CITY OF ALBUQUERQUE

September 29, 2016

**RE: Legacy NAA Apartments
Grading and Drainage Plan & Report
Engineer's Stamp Date 9-15-2016 (File: C18D064B)**

| ENGINEER'S SEAL<br><br>4/8/16<br>DAVID SOULE<br>P.E. #14522 | LEGACY NAA<br>APARTMENTS<br>GRADING AND<br>DRAINAGE PLAN                                                     | DRAWN<br>BY WCVJ<br>DATE<br>3-14-16<br>21601-LAYOUT-1-07-16 |

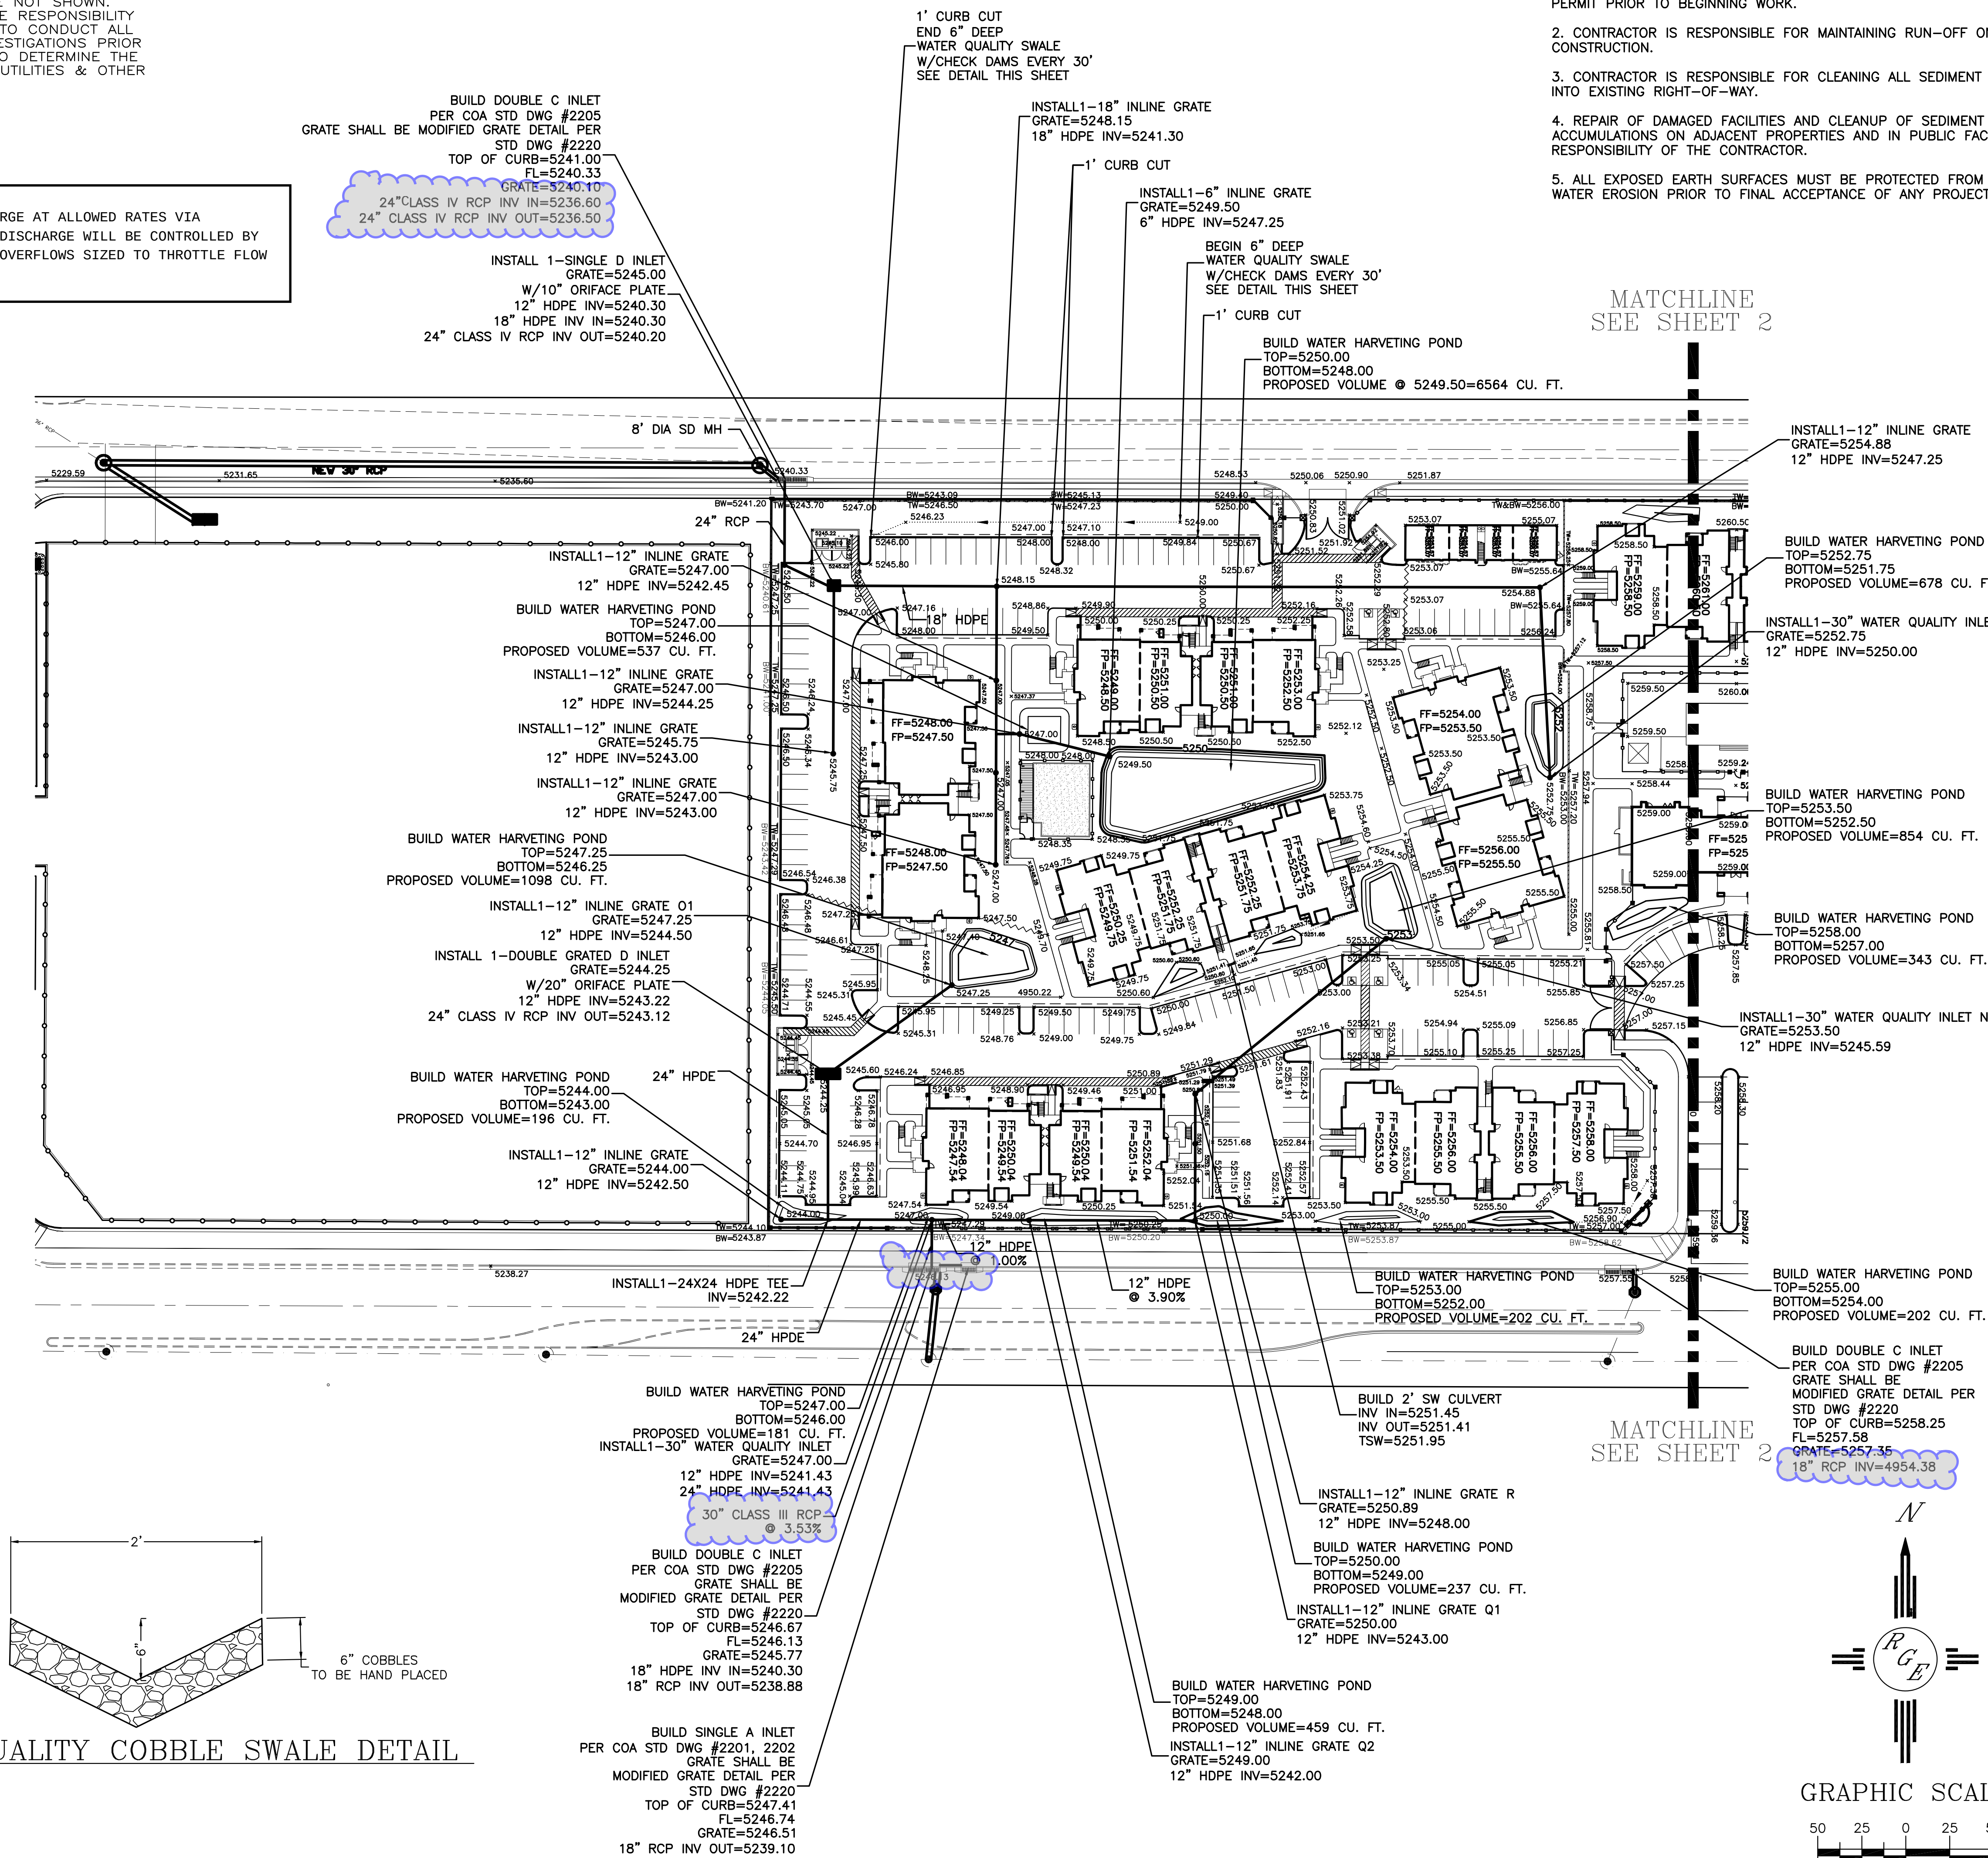
1. Ensure that the Contractor receives the modified grate detail (Std Drawing #2220) to use on this project.
2. Ensure that the Contractor receives a legible version of the detail sheet.
3. The placement of the inline drains which was referenced in our previous review letter will be reviewed at CO.
